**Red Text** = The El Paso County Comments Rev. 0

**Green Text** = The Engineer of Record answers on the El Paso County Comments Rev. 0 for Variance of Use project

## 1185 N Curtis Rd, Colorado Springs, CO 80930

PROJECT NAME:  
**VARIANCE  
OF LAND USE**

TITLE:
SITE PLAN PROPOSED CONDITION

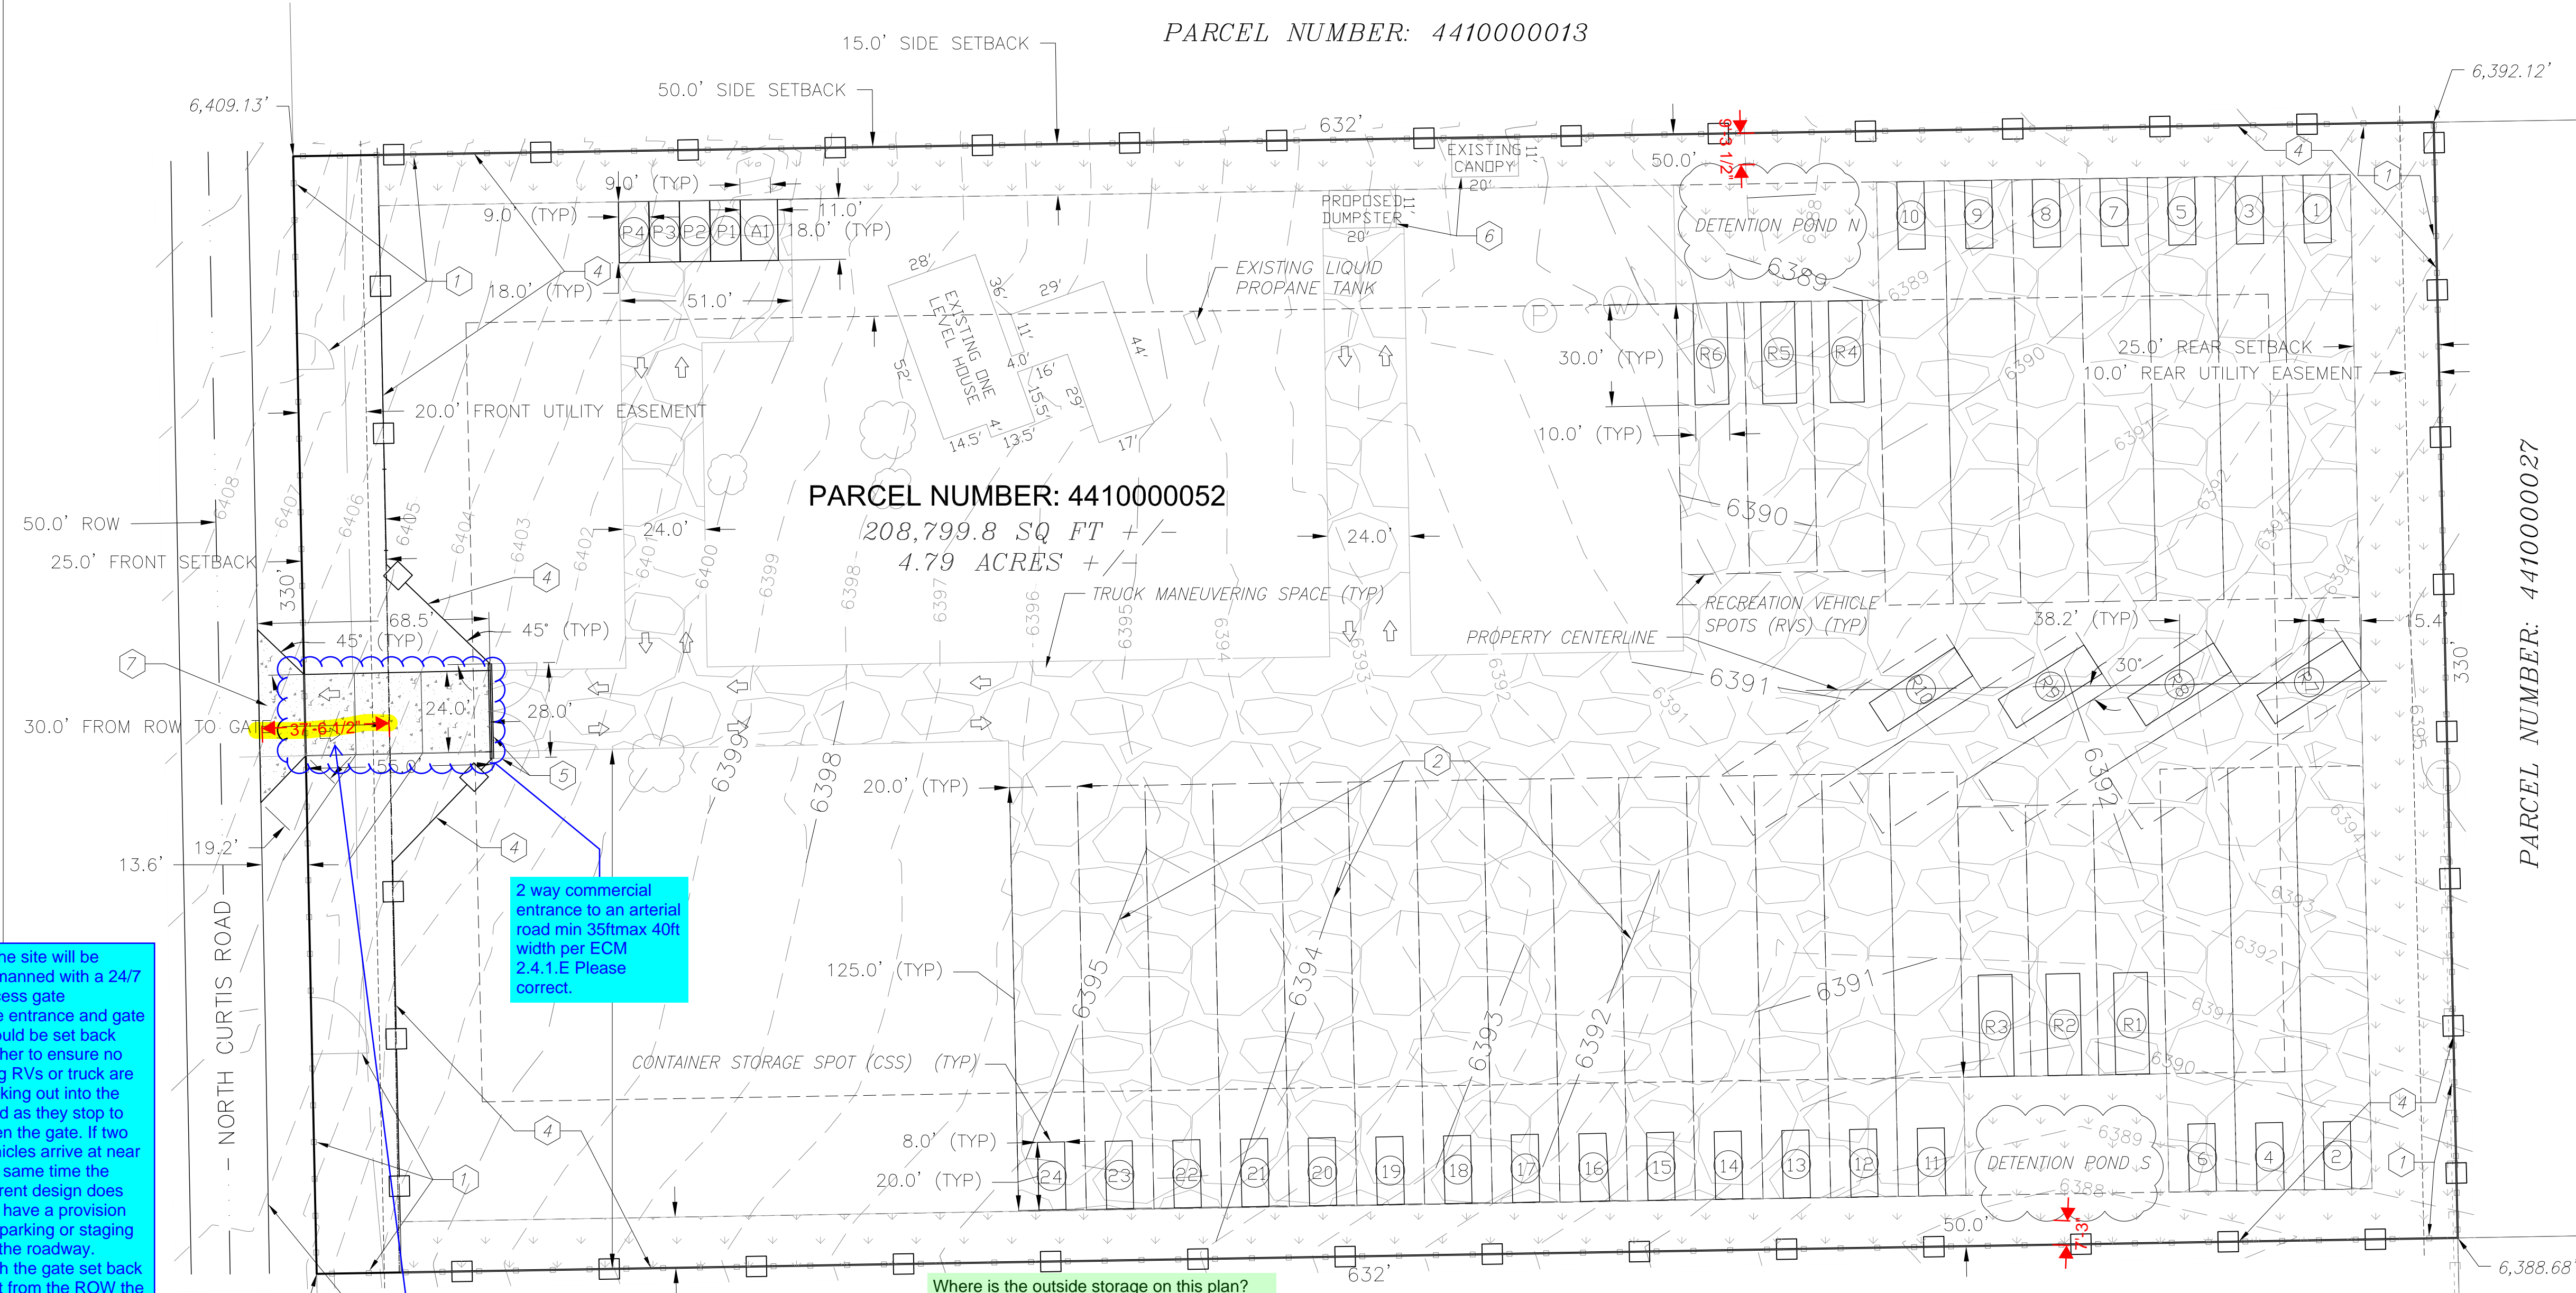
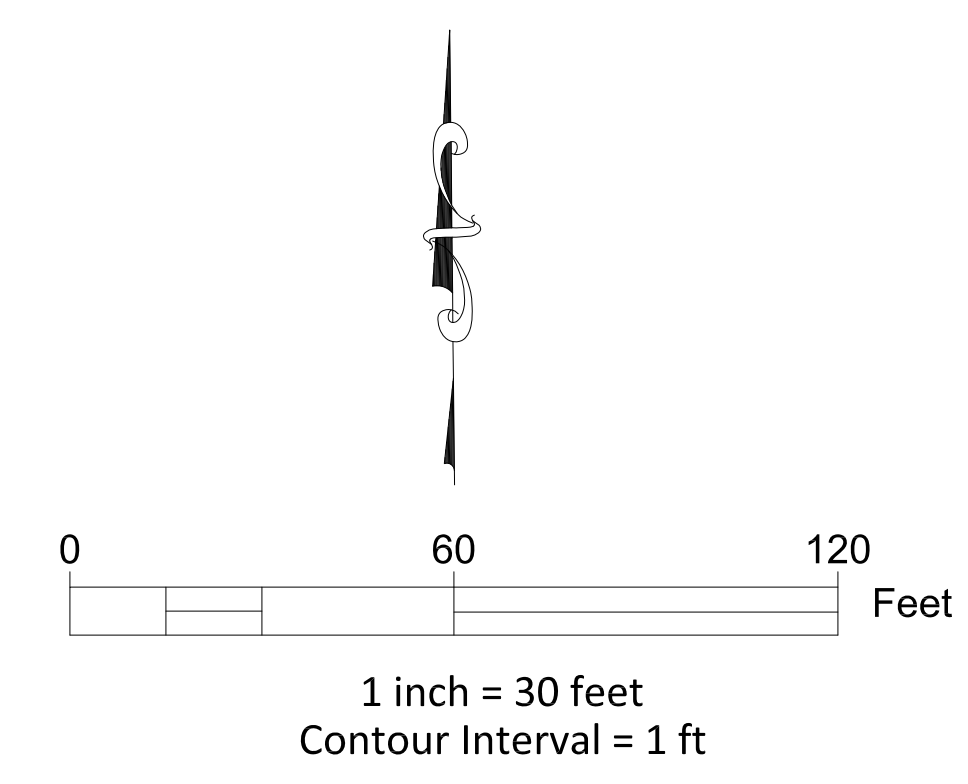
20. Show a driveway

21. List the ROW, road class

22. Account for increased ROW width from MCTP road project to an improved 2 lane principle arterial with ROW of 100ft.

23. Show and label entrance. Only one entrance can be permitted

24. This site plan shows the entire lot being turned to gravel. Please correct site plan overall. Review of the site plan cannot be completed due to missing elements.

27. Show all parking areas, drive aisles, RV parking pad sites by exact dimensions and layout. Show all gates with setback from road per LDC 30ft

28. Traffic circulation on site including all points of ingress/egress into the property

29. Show and provide tabulated RV parking stall #s.

30. Plan for required water quality and detention structures in the site plan with required landscaping

✓ Driveway is shown on Sheet #: S-2.

✓ The ROW and road class is presented on Sheet #: S-2.

✓ The ROW from MCTP is 100 ft and it is presented on Sheet #: S-2.

✓ Show and label entrance is shown on Sheet #: S-2.

✓ Only one entrance is shown on Sheet #: S-2.

✓ The site plan is corrected per comments and shown on Sheet #: S-2.

✓ All parking areas, drive aisles, RV parking pad sites, container storage spots, by exact dimensions and layout is shown on Sheet #: S-2. Show all gates with setback from road per LDC 30ft is shown on Sheet #: S-2.

✓ The traffic circulation including all points of ingress/egress into the property is presented on Sheet #: S-2.

✓ Tabulated RV parking stall #s is presented on Sheet #: S-2.

✓ Plan for required water quality and detention structures with required landscaping is presented on Sheet #: S-2.

SHEET NUMBER:
 S-3

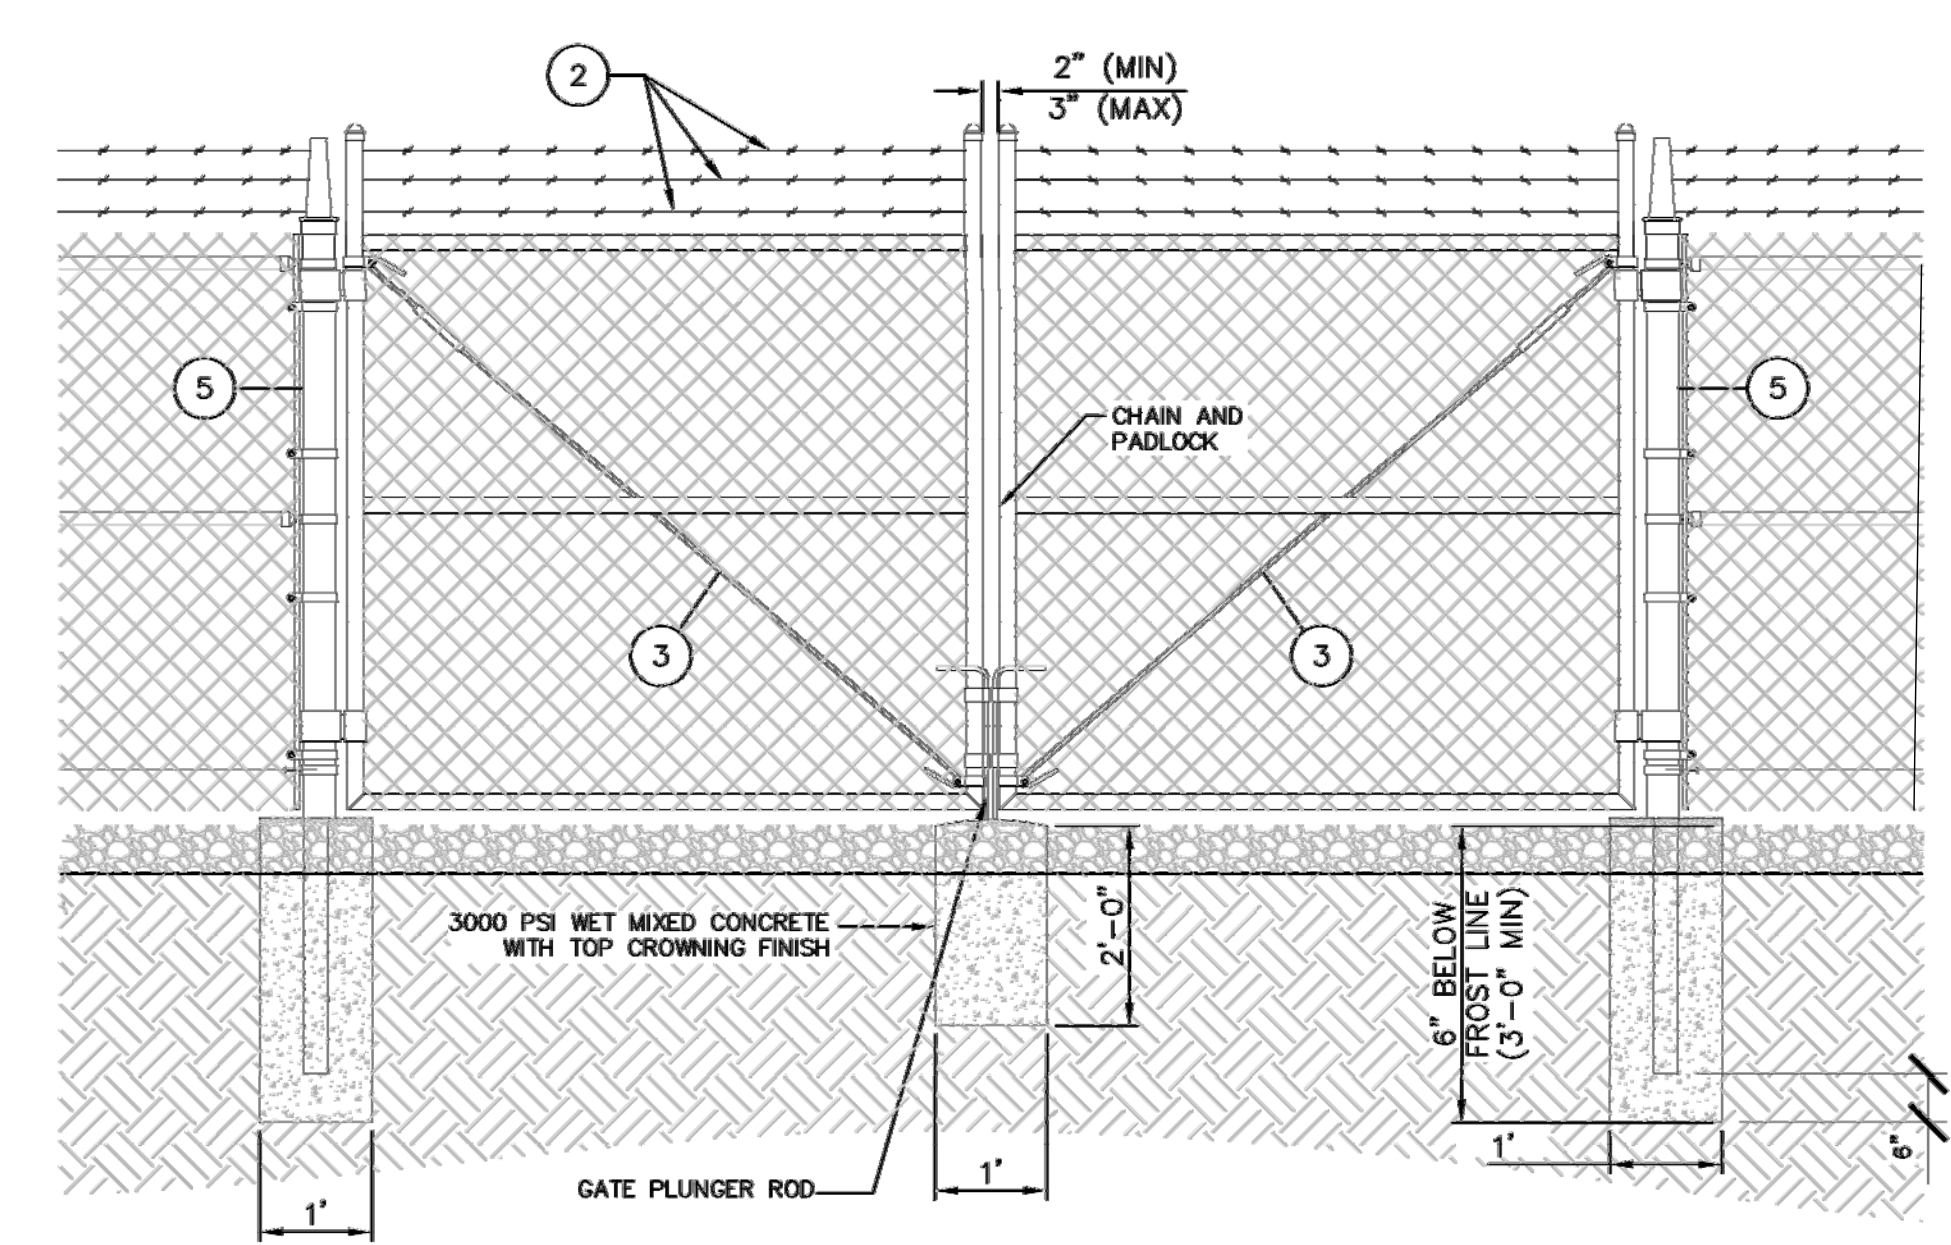
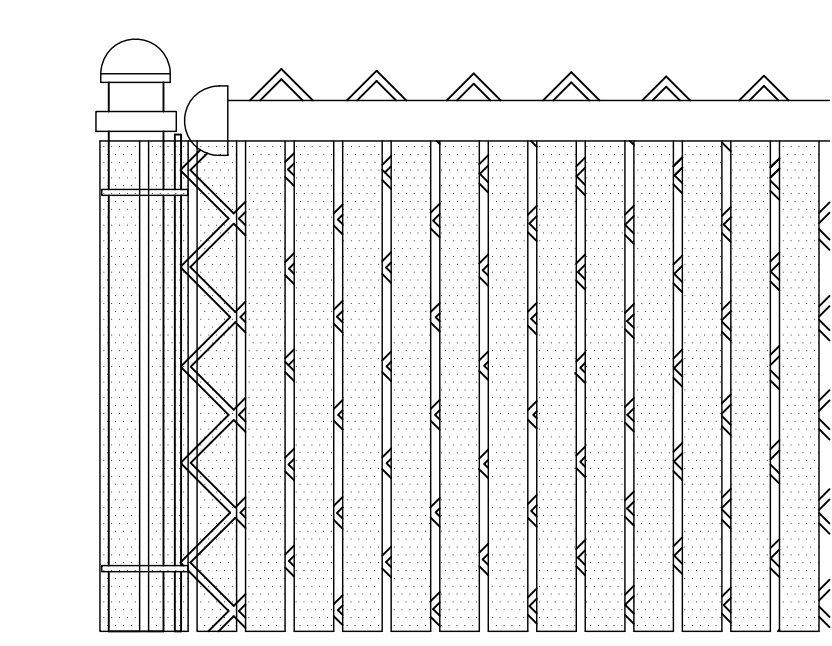
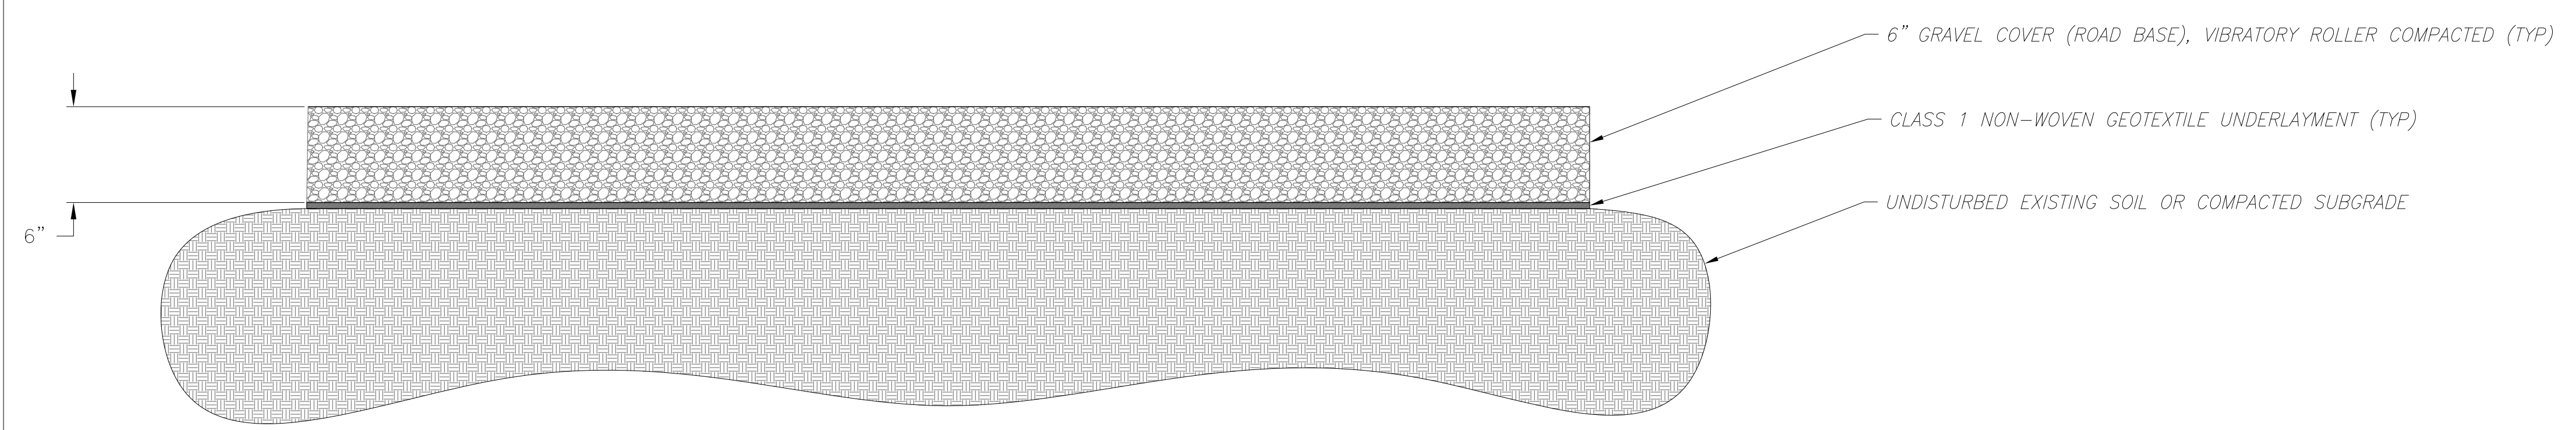
32. Please update fencing to reflect requirements of code:

(2) Materials Screened by Solid Fence or Vegetation. Outside storage shall be enclosed and concealed by a solid fence or wall at least 6 feet in height or any combination of berming, shrubs, trees fencing or walls which will provide at maturity a minimum of 6 feet of height and 100% opaque screening for the area utilized for outside storage.

✓ Fencing is update to reflect requirements of code as presented on Sheet #: S-3.

✓ (3) Outside Storage Not to Exceed Height of Screening. Outside storage or stacked materials shall not exceed the height of the screening fence except for operable vehicles, trailers, or other equipment designed to be towed or lifted as single component.

✓ This code is satisfied since all equipment are designed to be towed or lifted as single component.
